**SSD-9274 – SAMUEL GILBERT PUBLIC SCHOOL
SECTION 4.55(1A) MODIFICATION APPLICATION**

This application has been prepared by Ethos Urban on behalf of NSW Department of Education, School Infrastructure NSW (SINSW), pursuant to Section 4.55(1A) of the *Environmental Planning and Assessment Act 1979* (EP&A Act) to modify Development Consent SSD-9274 relating to the redevelopment of Samuel Gilbert Public School, located at Ridgecrop Drive, Castle Hill (the site).

The modification relates to an administrative correction to the Kiss and Drop plan to ensure it aligns with the street sign layout approved by Council.

DRAWING NUMBER
A-S-1615

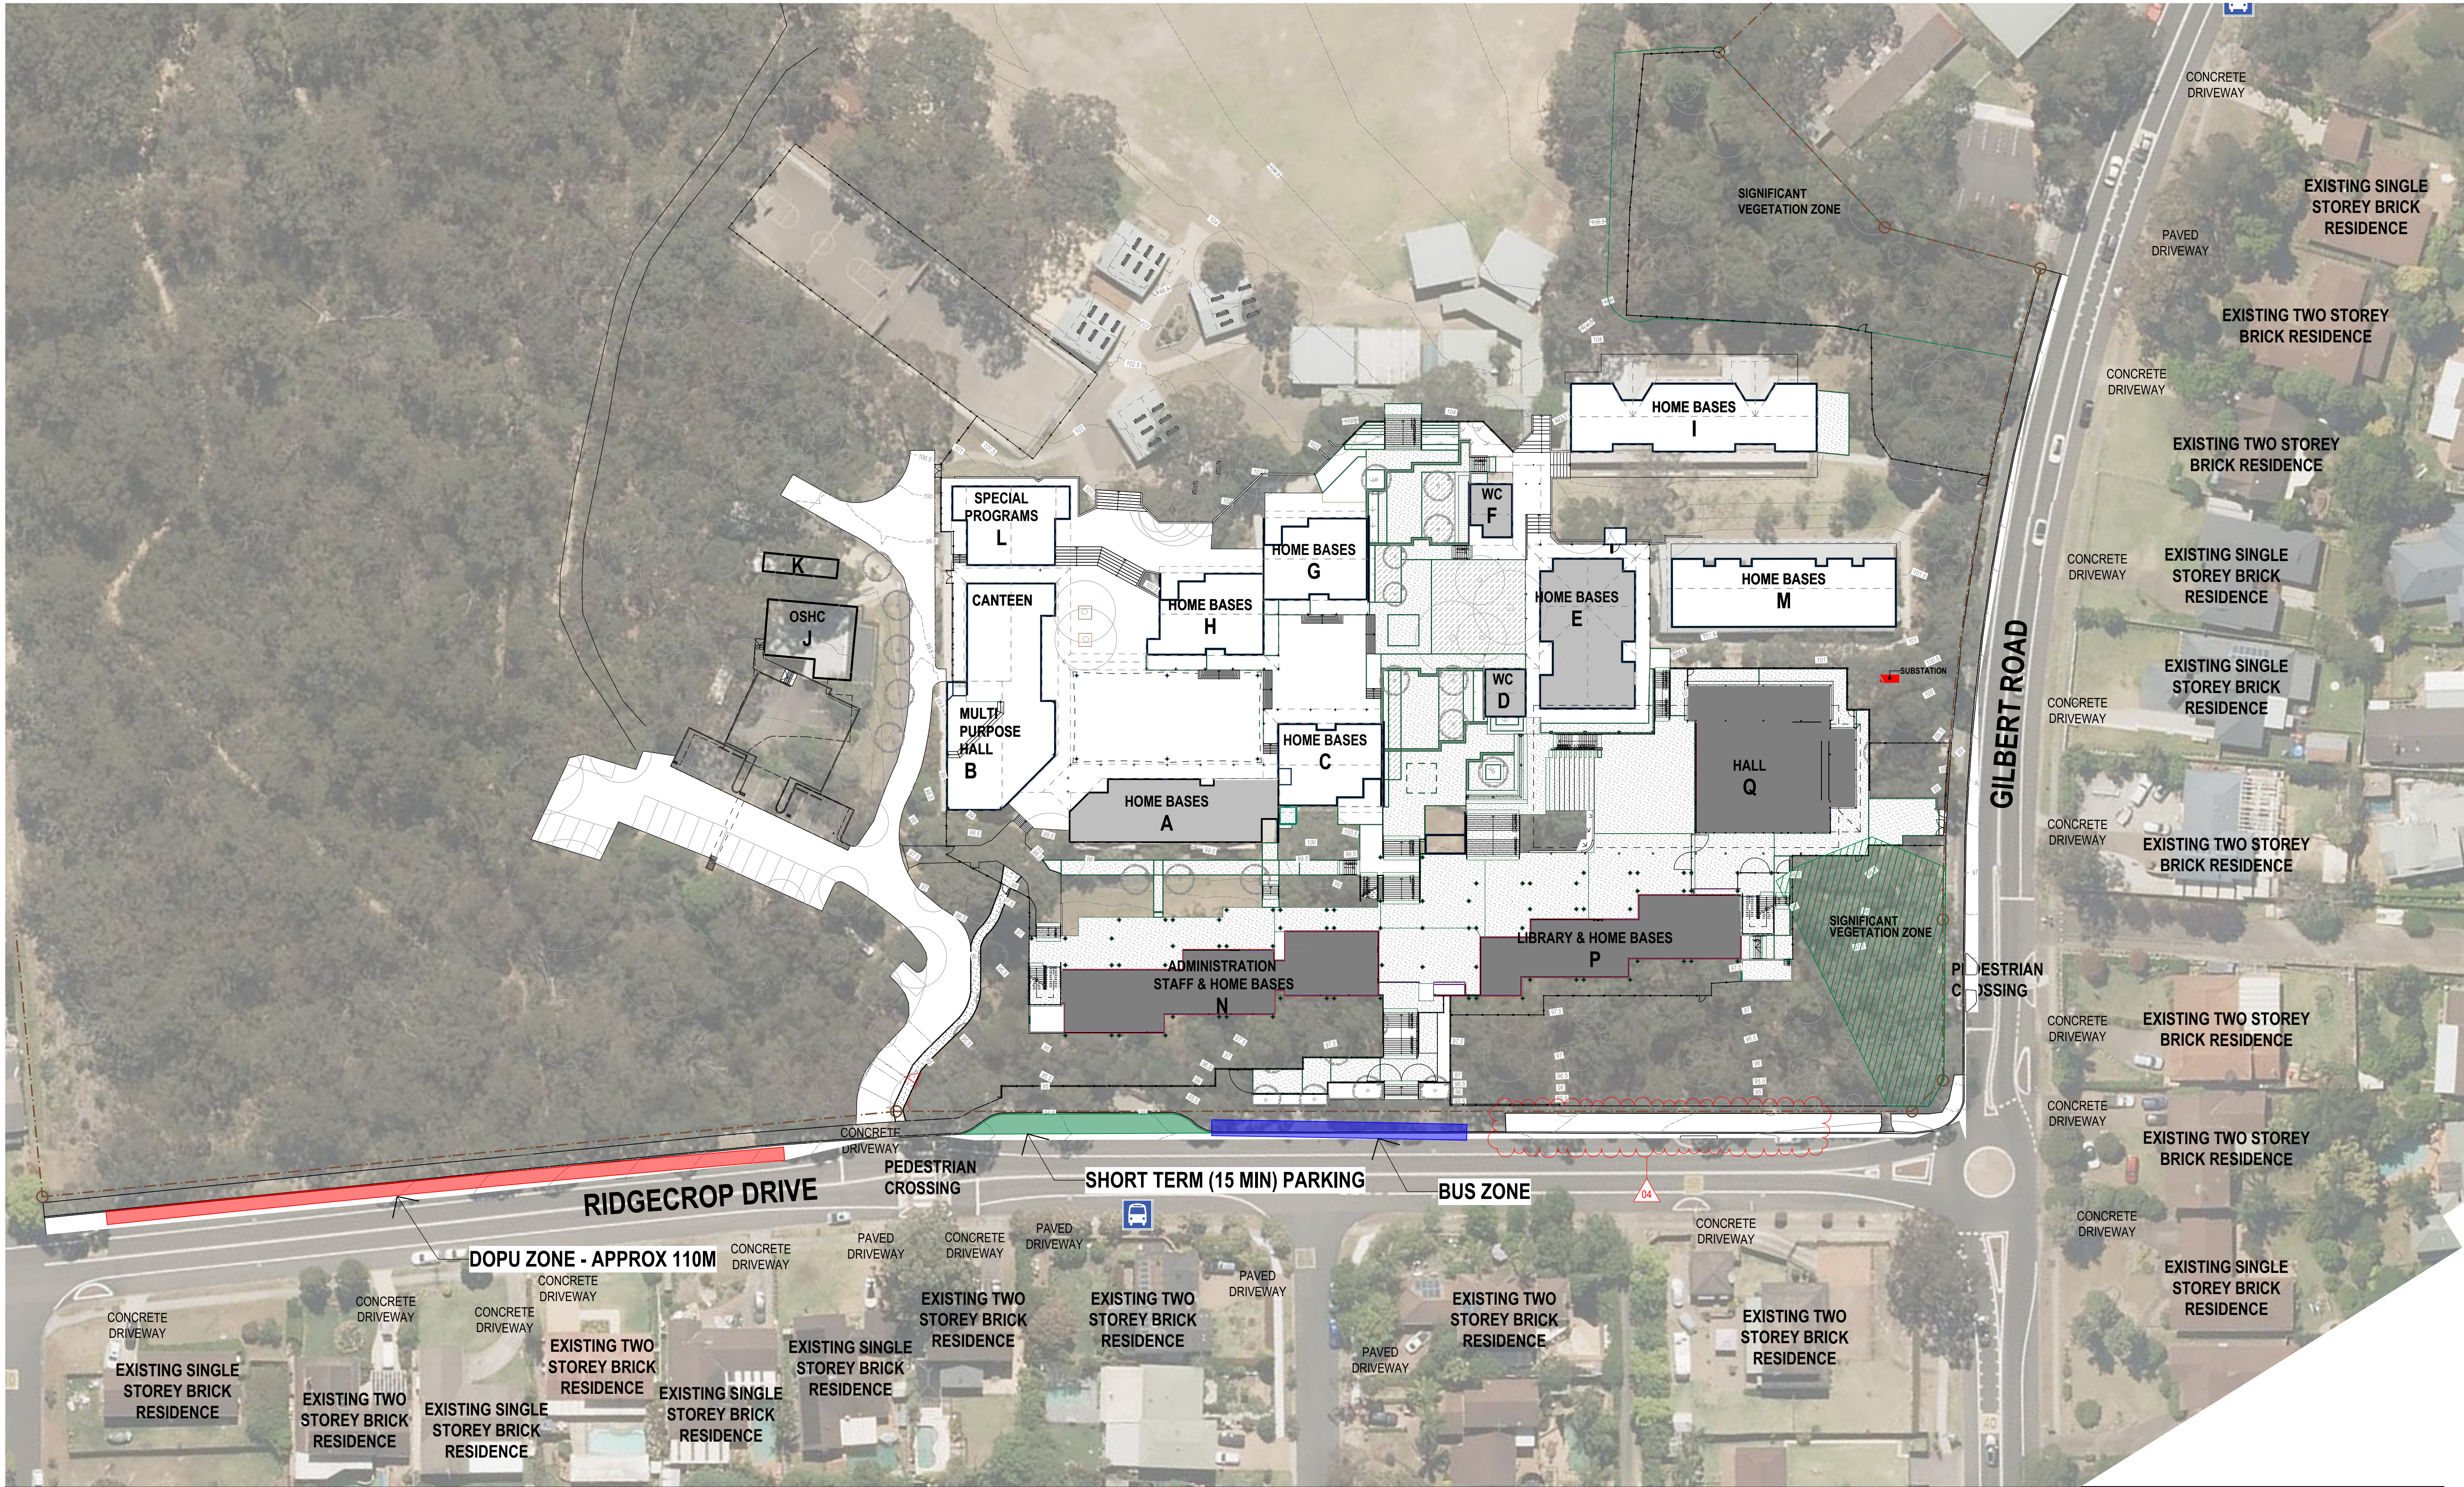
The modification proposes to correct an inconsistency in the extent of kiss and drop shown in the architectural drawings referenced in the consent and the layout of signage approved by Council and the Local Traffic Committee.

Modification 2, approved by DPE on 25 November 2021, amended the extent of kiss and drop proposed at the site. Modification 2 was intended to align with the layout endorsed by both Council's Local Traffic Committee on 19 August 2021 and Council on 24 August 2021. However, the Amended Kiss and Drop Architectural Plan provided for Modification 2 did not align with the Council approved layout. In particular, the Architectural Plan showed a 27m drop off and pick up zone on Ridgecrop Drive, towards the intersection with Gilbert Road, which was not present in the Council approved layout.

This modification seeks to provide an Amended Kiss and Drop Plan that corrects this inconsistency by not showing the 27m pick up and drop off zone, to align with the Council approved layout of street signs.

DWG No.	Rev	Name of Plan	Date
...
A-S-1615	03 04	<i>Kiss and Ride</i>	11/05/21 07/02/22
...
